EPPING PARK: STAGE 2 – BUILDING 10

ACCESS REVIEW

Morris-Goding Accessibility Consulting

20th June 2011

1 GROUND FLOOR PLAN
1 : 100

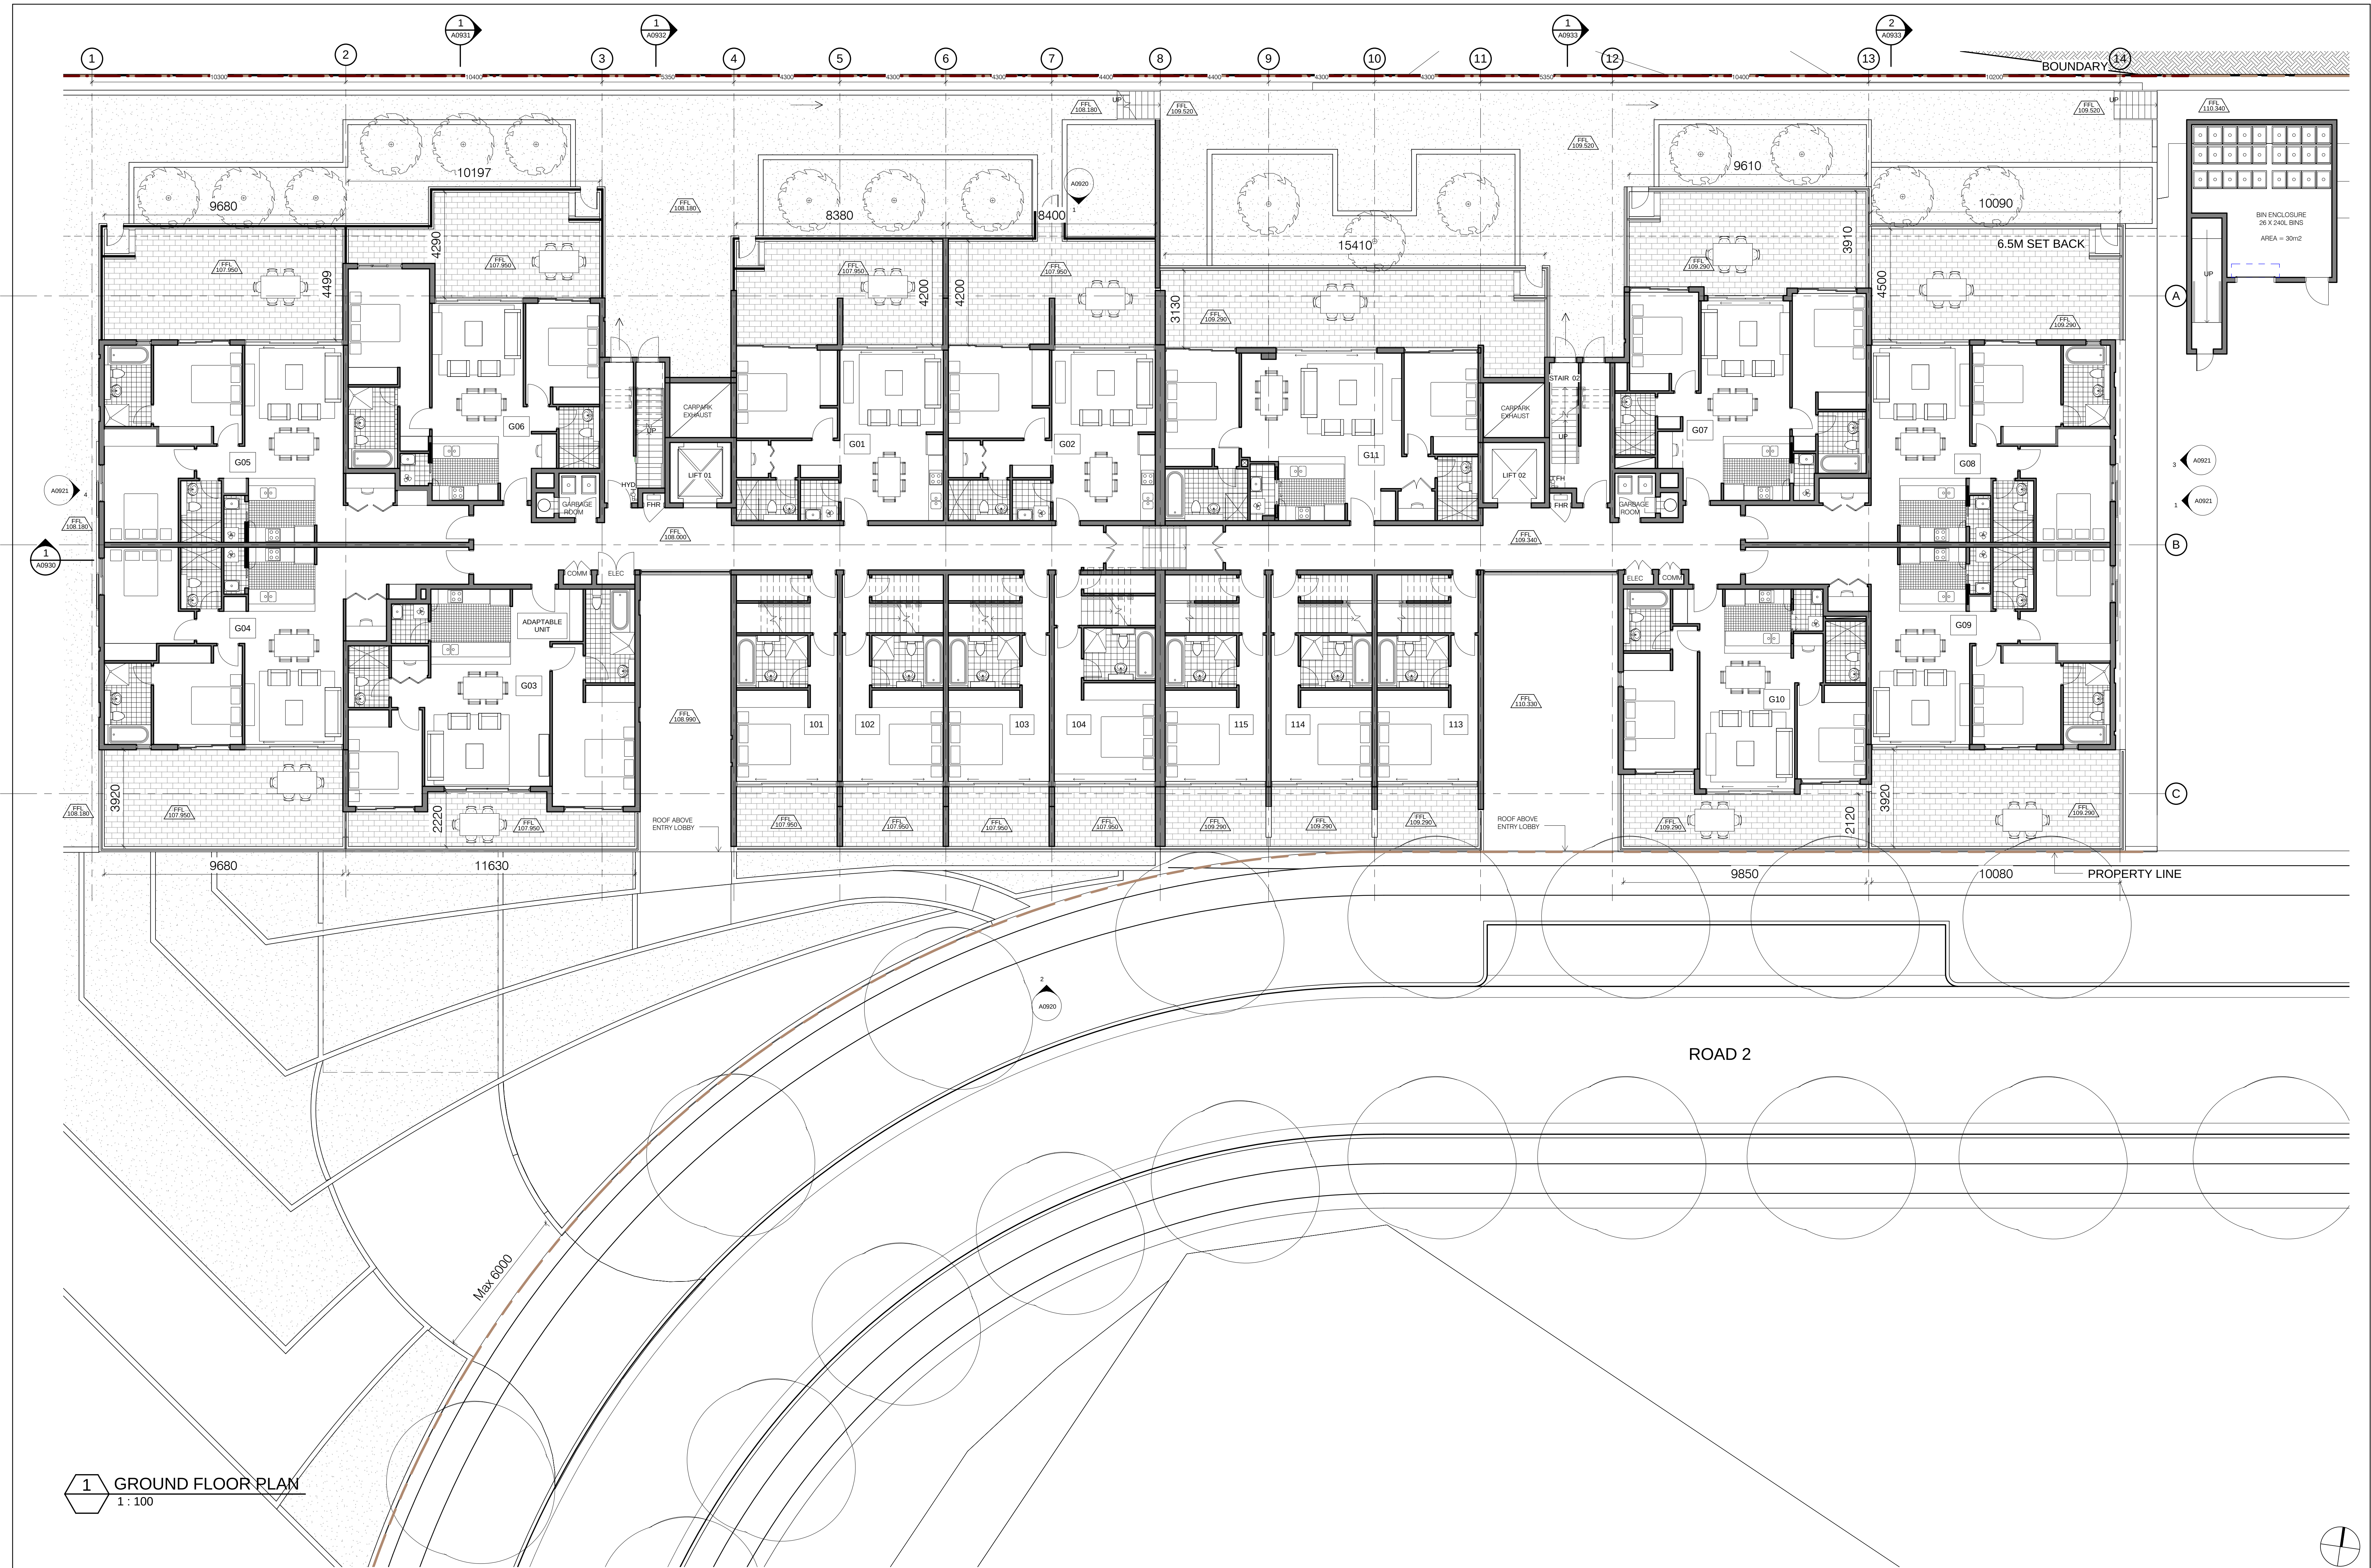
There is a WC located within the Manager's Office with internal dimensions of 1270mm x 2645mm.

- (i) Provide an accessible WC within the Manager's Office with 850mm clear width and 510mm latch side clearance.
- (ii) The WC requires 1900mm x 2300mm circulation around the pan, the basin is to sit outside of this area and may only encroach by a maximum of 100mm compliant with AS1428.1:2009.

1 LEVEL 1 FLOOR PLAN
1: 100

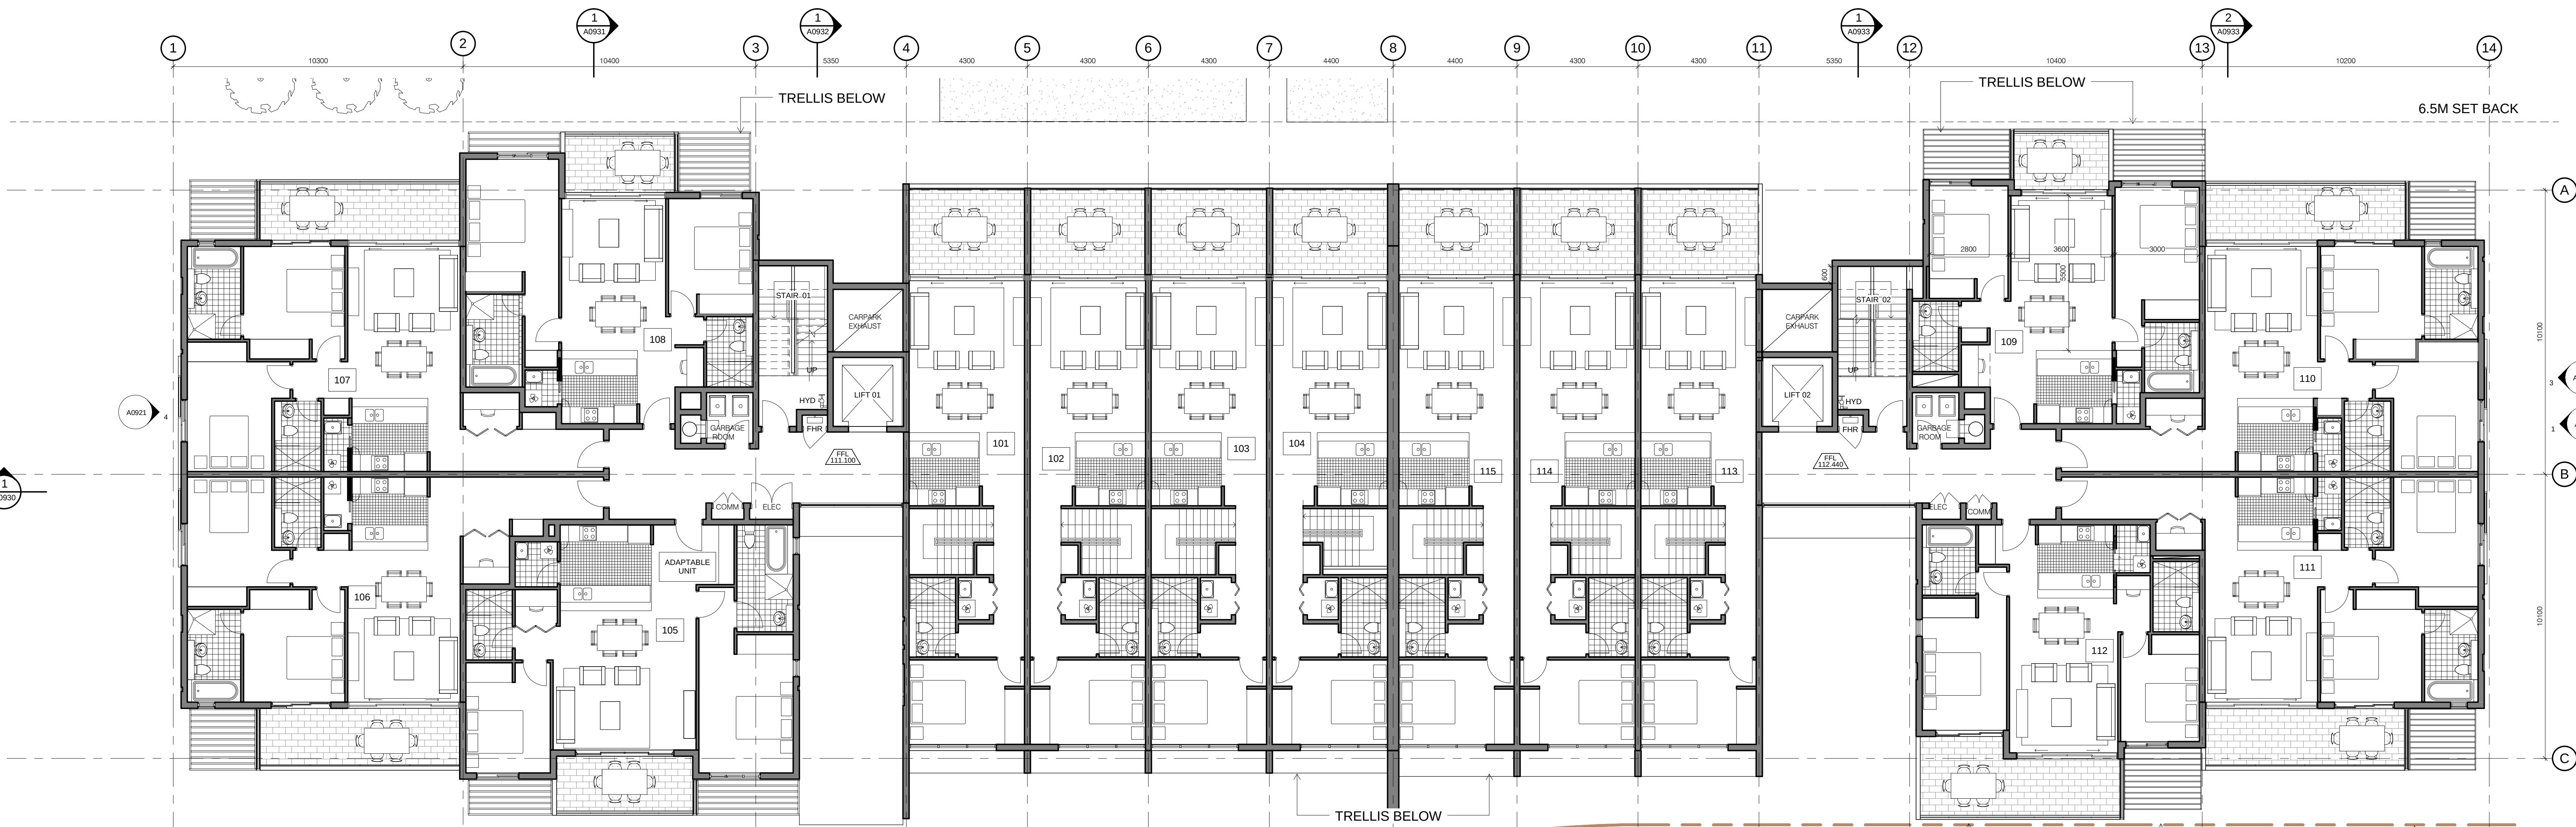
The main bedroom has a 830mm clear width door compliant with AS4299. There is a 1135mm clearance on the internal leaf of the door which will need to be enlarged to ensure wheelchair side approach compliant with AS1428.1:2009. The bedroom has internal dimensions of 3120mm x 3385mm outside the robe area

The accessible ensuite has a 715mm clear width door. The door has a 460mm latch side clearance. The toilet has internal dimension of 1950mm x 3780mm which will need to be enlarged to ensure an appropriate circulation area around the pan, basin and shower recess.

The laundry has a 715mm clear width door. There is insufficient internal latch side clearance provided. The laundry has a 1050mm clearance in front of laundry appliances non-compliant with AS4299.

- (i) The main bedroom requires minimum internal dimensions of 3.6m x 3.6m suitable for wheelchair manoeuvrability.
- (ii) Ensure a 1240mm clearance at the internal leaf of the bedroom door suitable for wheelchair side approach compliant with AS1428.1:2009, fig. 31.
- (iii) Ensure the accessible toilet has a clear width of 820mm compliant with AS4299.
- (iv) Bathroom (shower, toilet, wash basin) to comply with circulation area requirements of AS1428.1:2009, that is provide an area of 1900mm x 2300mm around the pan. The wash basin should sit outside this area, and if needed only encroach into this area by 100mm (max). The shower area requires 2500mm x 1600mm. An internal dimension of 2.3m x 2.7m will satisfy this requirement.

- (v) Laundry door to have a minimum 850mm clear width and 510mm latch side clearance on the internal leaf suitable in accordance with AS1428.1:2009.
- (vi) The laundry requires a minimum 1550mm turning circle in front of laundry appliances compliant with AS4299.

1 PARKING LEVEL
1:100

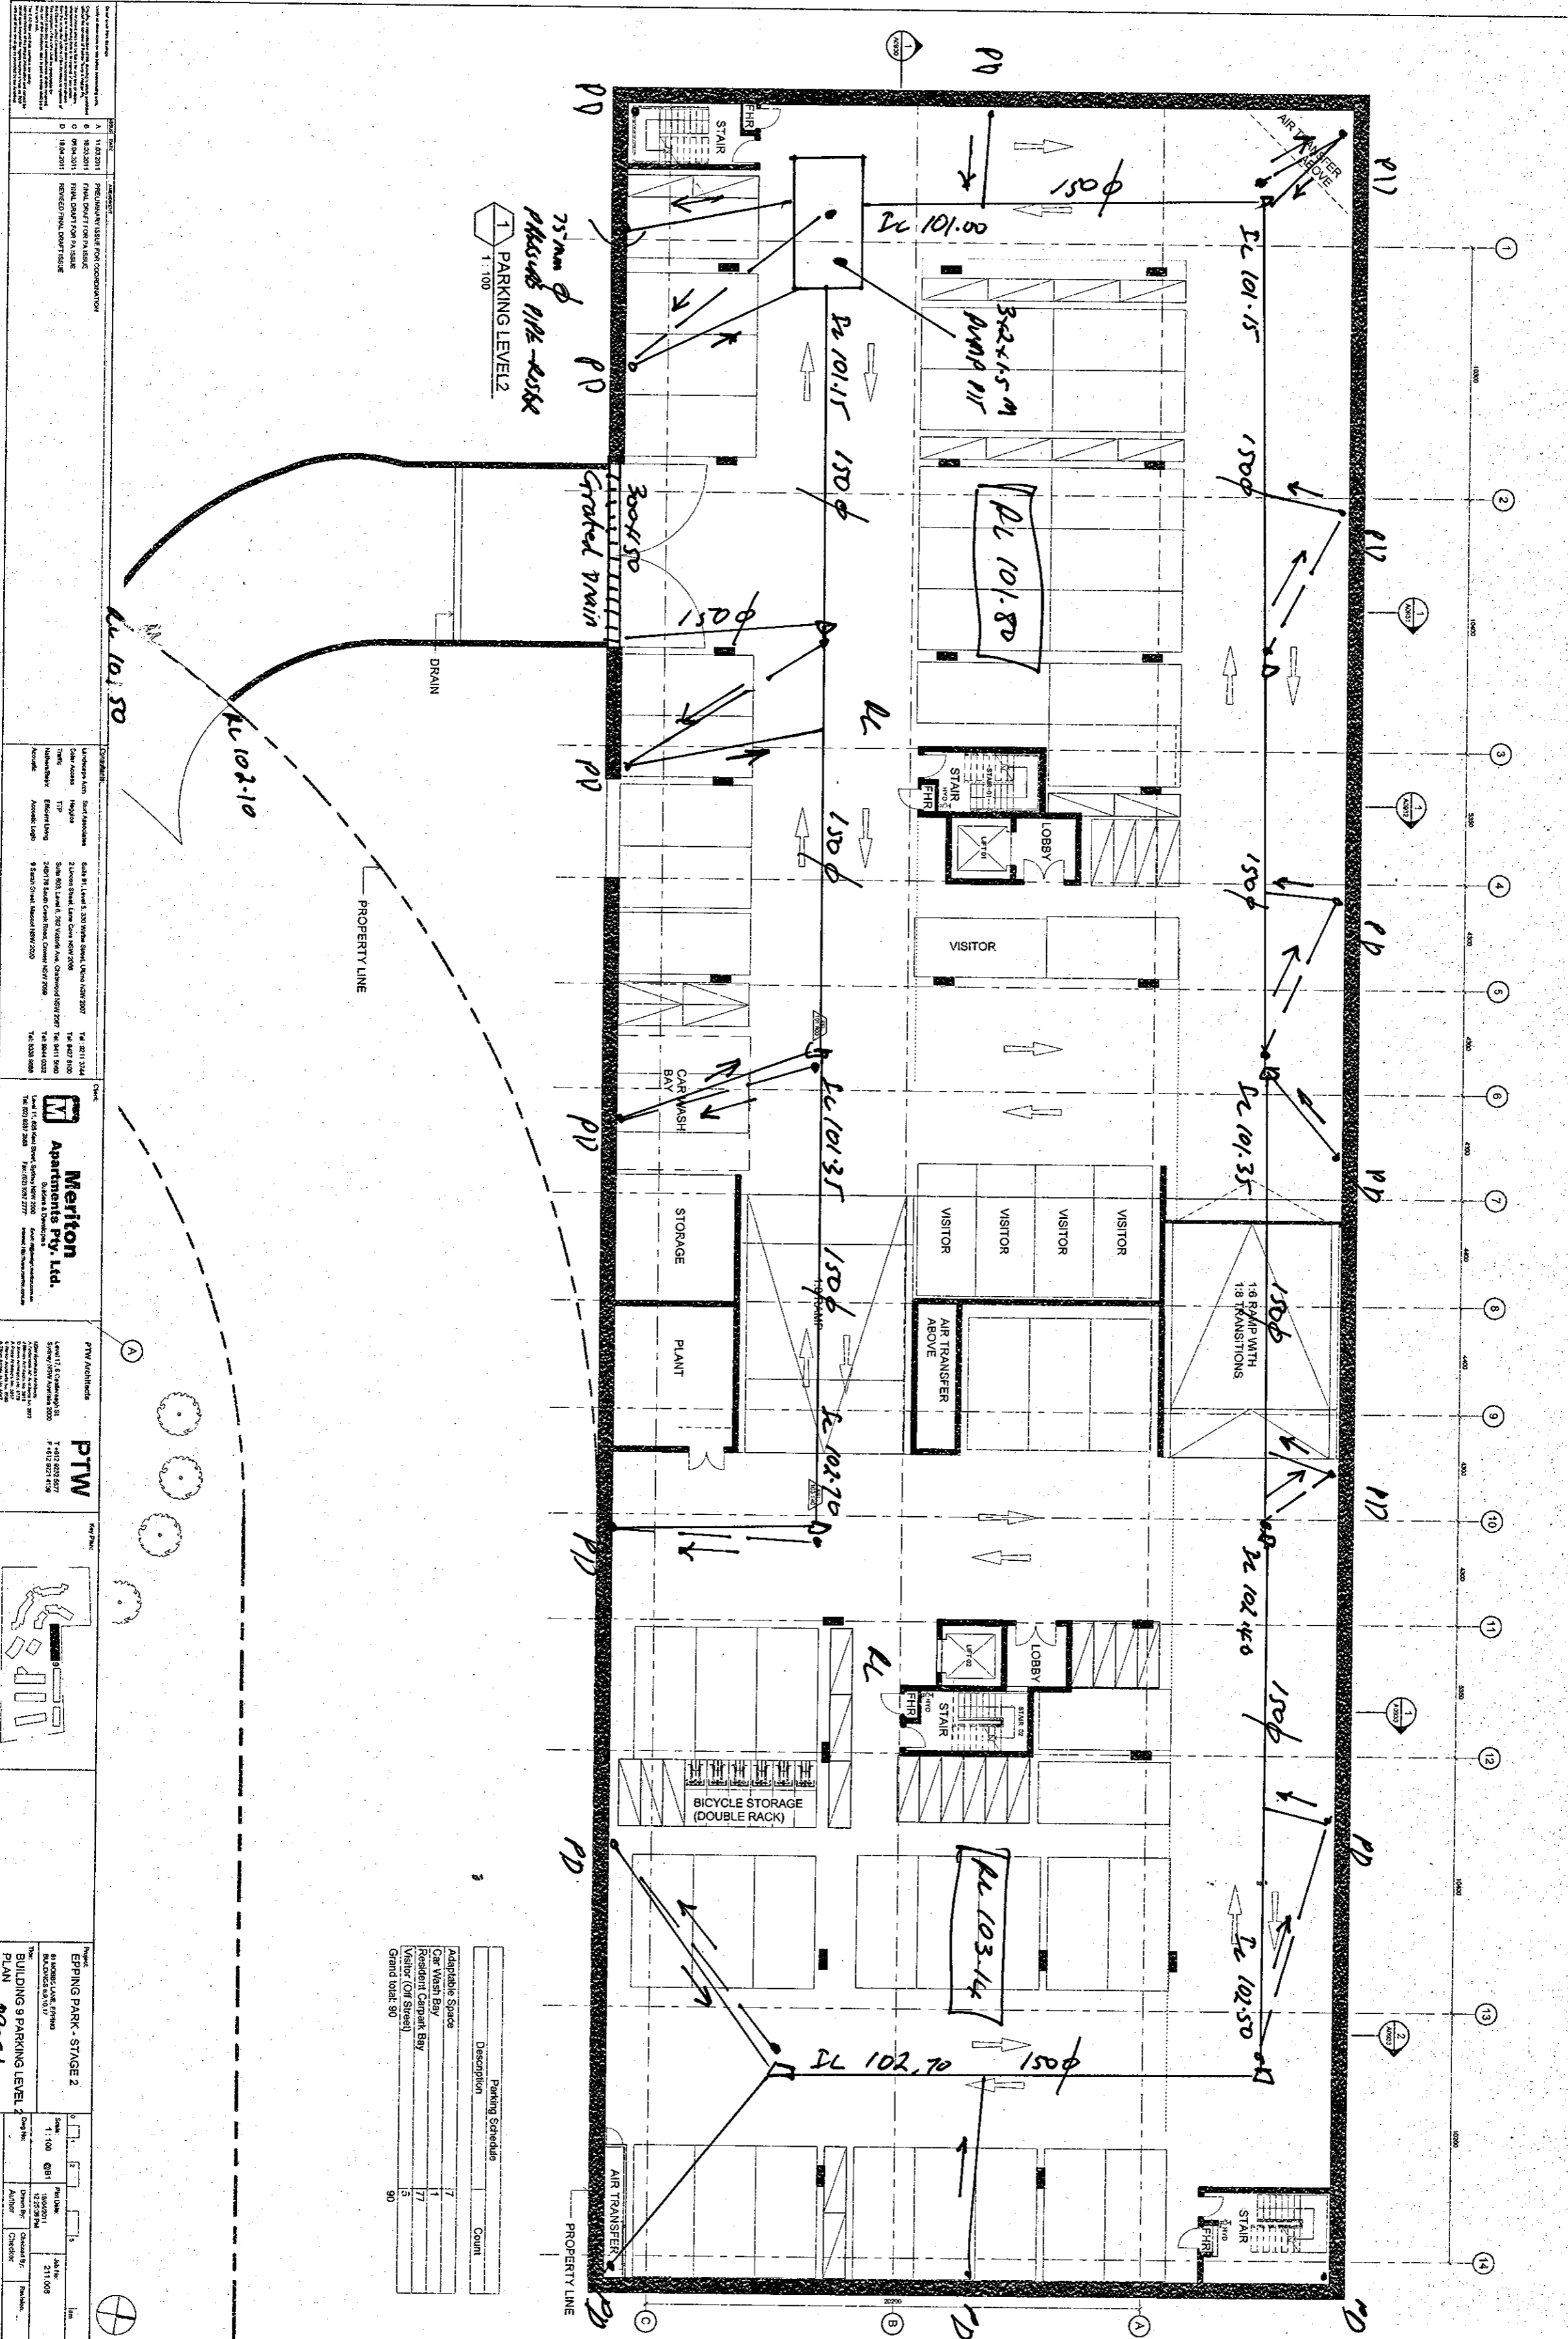
Car bays are allocated adjacent resident lift lobby which provides an accessible path of travel to the adaptable units above compliant with AS4299. The lobby on parking level 1 is accessed via dual-hinged entry doors. The doors have a clear width of 800mm. An AS1428.1:2009 compliant doorway is achievable.

- (i) Parking level 1 lobby door requires an 850mm clear width compliant with AS1428.1:2009.
- (ii) All accessible car bays require a height clearance of 2.5 metres and 2.2m vertical clearance upon approach to each car bay.
